June 17, 2004

RE: Logan Place, 52 Frederic Street

CBL: Chart 76, Block A, Lots #1-8

The Planning Board approved the Logan Place site plan with conditions on November 25, 2003 (refer to attachment). The conditions of the Planning Board approval have been met. On June 16, 2004, the City of Portland received a site plan application for an amendment to the approved site plan for Logan Place. The revised site plan is in compliance with the City's site plan and technical design standards and is approved by the Planning Division to proceed and receive a building permit with the following conditions to be met prior to the pre-construction meeting:

**Title:**  
GRADING, DRAINAGE  
AND UTILITIES PLAN

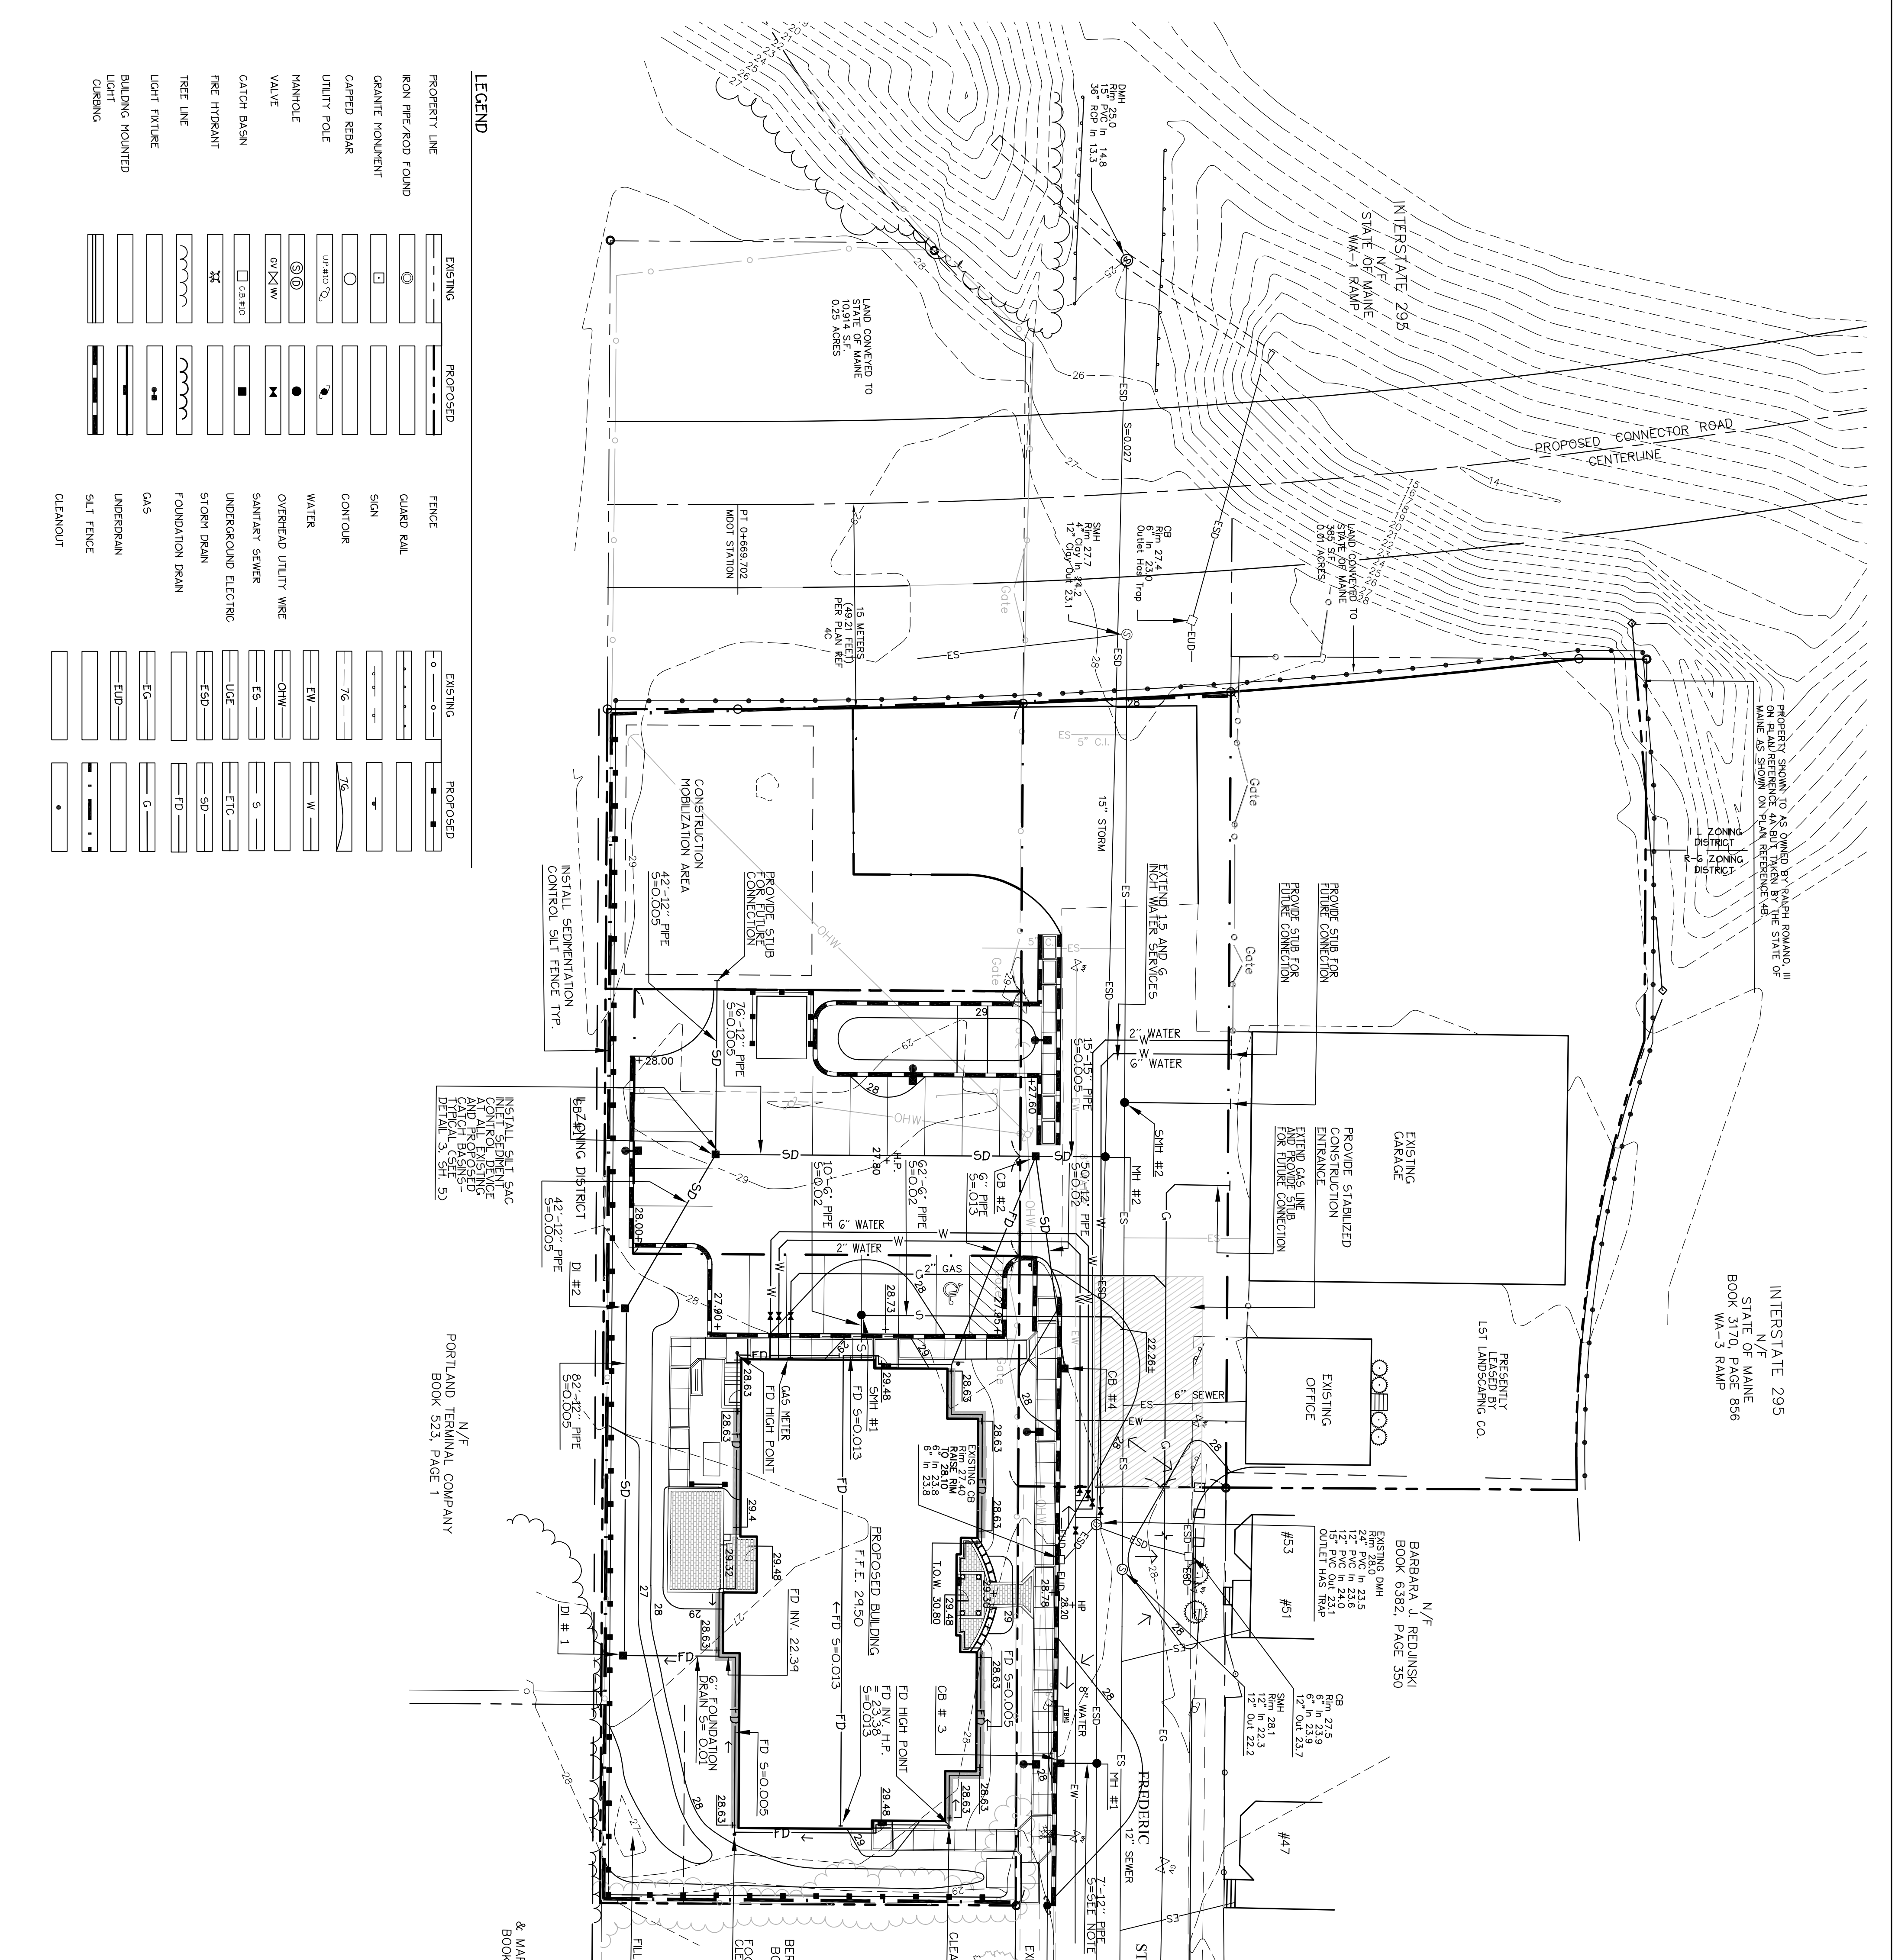
- A. The road section of the proposed reconstruction of Frederic Street indicates that the centerline grade is very nearly the City minimum slope of .005 ft/ft, but the gutter line is above the minimum at 0.0067 ft/ft. Given the discussions at our meeting, we believe that the design is acceptable with the following conditions:

2. The existing CB along the front curb in Frederic Street is shown to be raised; additionally, a new curb inlet stone shall be set in place in accordance with City standards. This shall be reflected on the same time and plans as noted above.

- B. The applicant has addressed the issue regarding the snow storage/construction mobilization area drainage. The use of the perforated pipe and French drain system will work as a means to address the drainage from snow melt between the project's two phases.

- C. The applicant has discussed the alignment of drainage structures and connections within the vacated portion of Frederic Street, and has properly shown these drain systems. Due to the potential of sediment entering the City drain system from the French Drain Mobilization Area, we suggest that the first catch basin (CB #1) be constructed with a three foot sump instead of the standard two foot sump to allow for more storage of sediment.

- D. The sidewalk is approved along the curb edge of Frederic Street with the condition that the owners remove snow and maintain clear passage for pedestrians.

1. The applicant shall provide a plan and profile section of the street that is within the City's jurisdiction and indicate the limits of shimming, full depth reconstruction, and/or grinding with full pavement overlay. Also, cross-sections shall be provided every 50 feet from where construction begins near 44 Frederic Street and where there are any manholes or catch basins located in the street. This is for both the City and contractor's use to establish final paving grade given the unusual circumstances and atypical cross slope. These drawings shall be provided to Planning and Public Works prior to a pre-construction meeting.
